Demolition of existing building & construction of 1 No retail unit & 3 No. flats with associated external works & access. This application affects the setting of listed buildings & may affect the character & appearance of the River Road, Littlehampton Conservation Area.

Littlehampton Covered Market 26-28 Surrey Street Littlehampton

LU/46/20/PL
26-28 SURREY STREET, LITTLEHAMPTON

SCHEDULE OF EXTERNAL MATERIALS

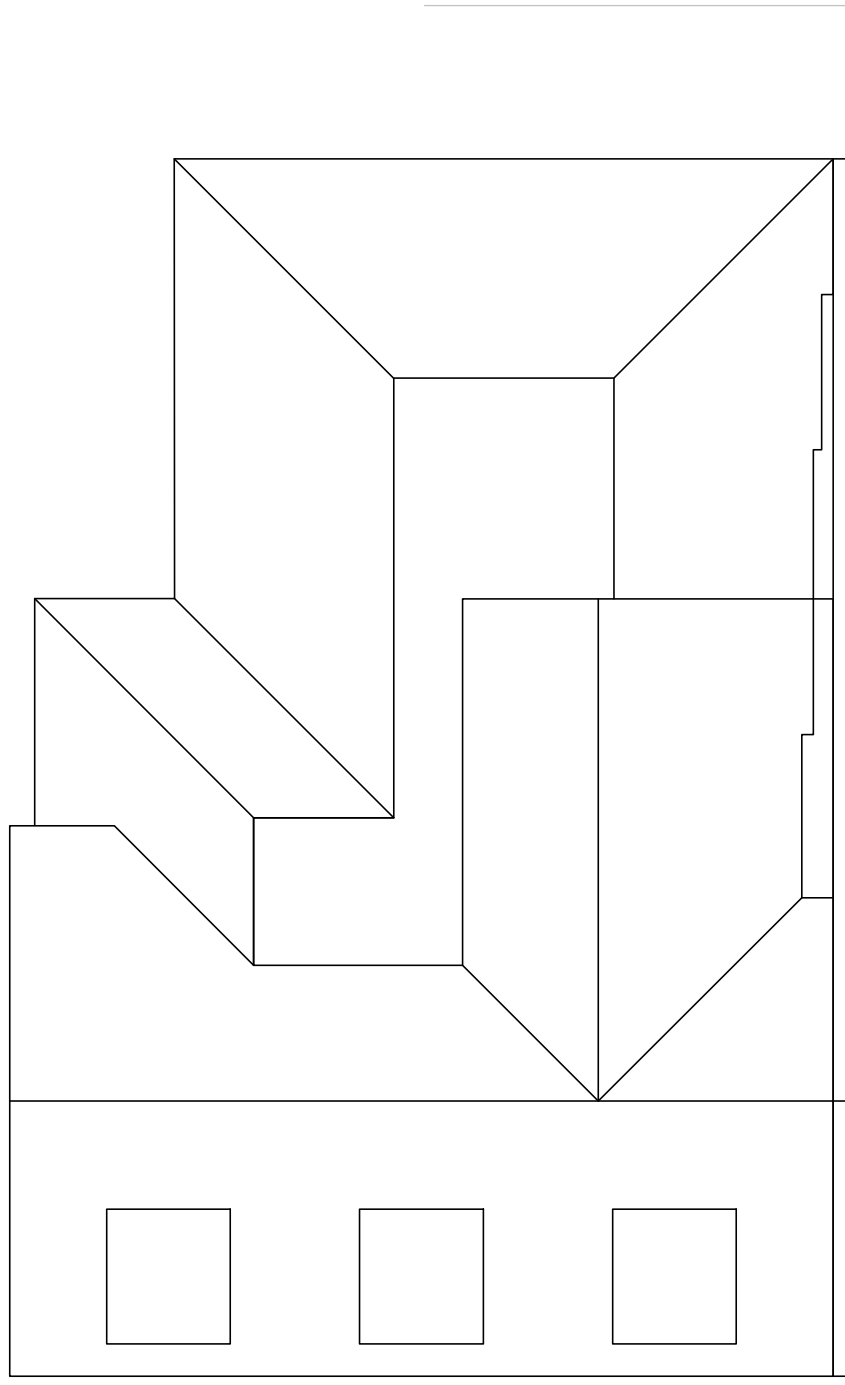
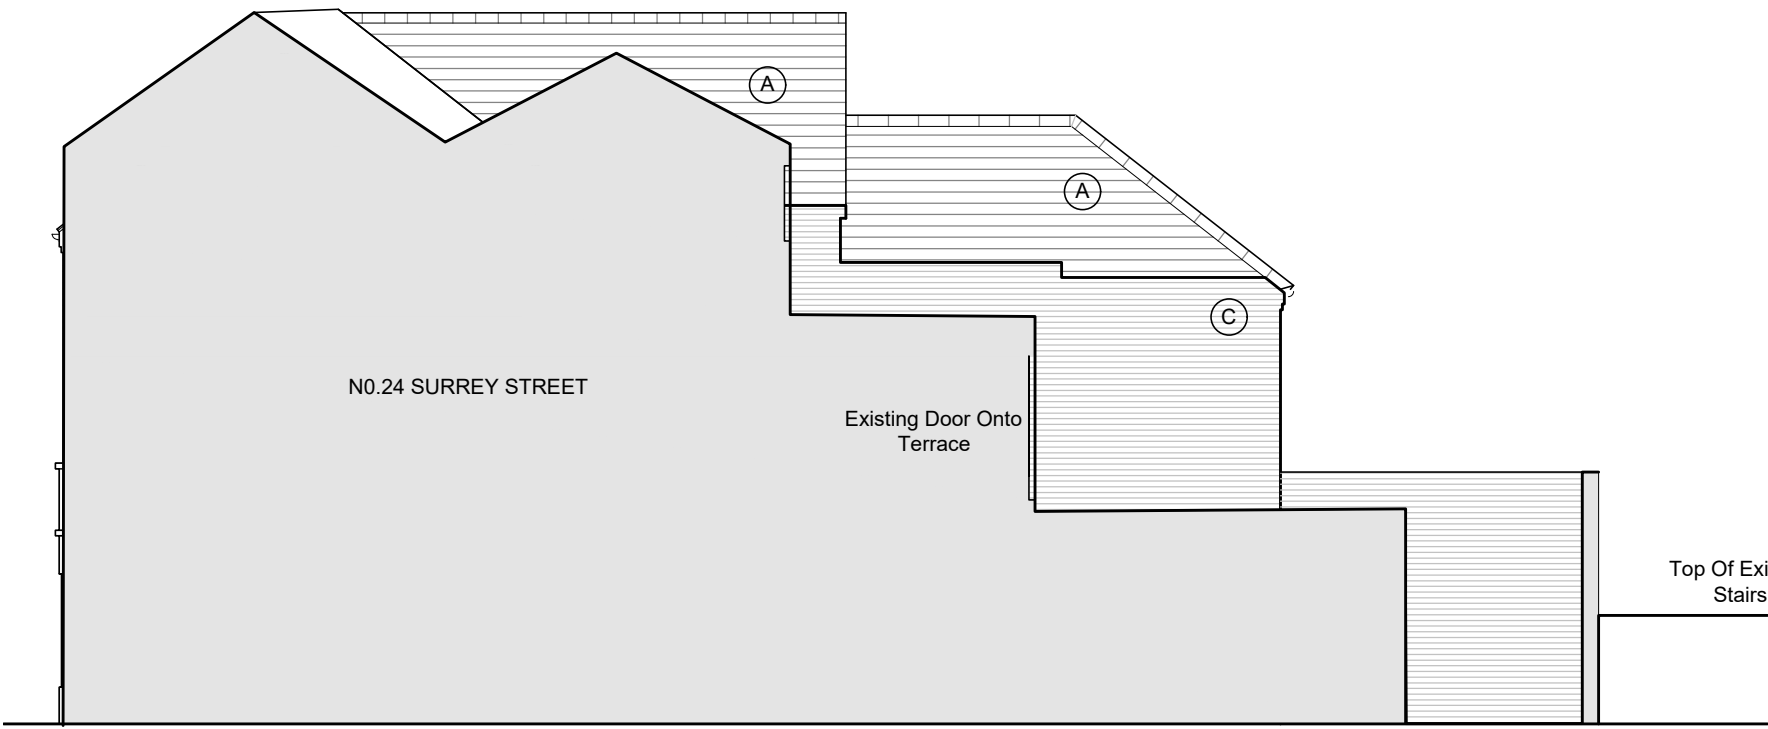
Although the Society has no objection to the general design of the proposed new building, it is concerned with aspects of the schedule of materials and finishes in the application. It will immediately abut a Grade 2 Listed Building and the choice of all materials is crucial. For instance, 'false slate tiles' and 'white sash effect windows' would be inappropriate in such a setting. Natural slate should be specified for the roof and properly formed painted timber vertically sliding sash windows are essential to protecting the setting of these designated heritage assets.
